Re; Submission on Byron Shire Central Hospital Major Project SSD 6573

Description: State significant application - Proposed Byron Shire Central Hospital

Report No. 13.8. **PLANNING – Submission to Department of Planning on Byron Shire Central Hospital**

1.1 Western Access – 1 Lane Roundabout

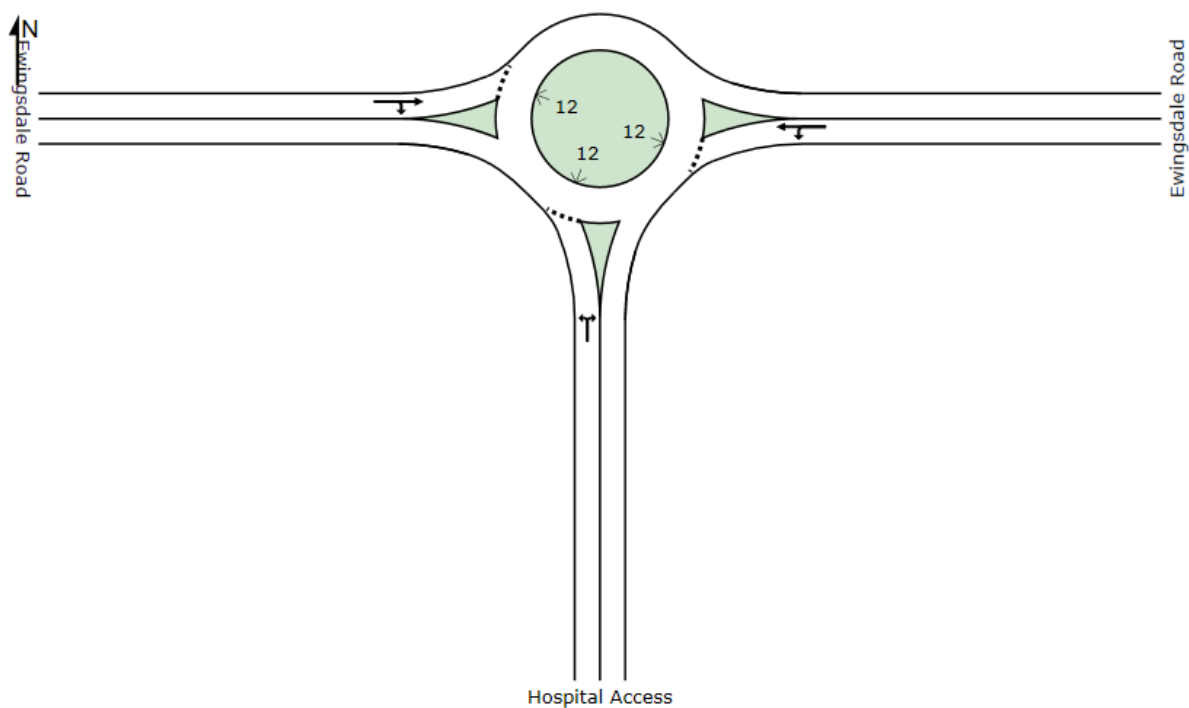
The application proposes a single lane roundabout. Currently all Council road studies and section 94 plan propose dual lane roundabouts on Ewingsdale Road.
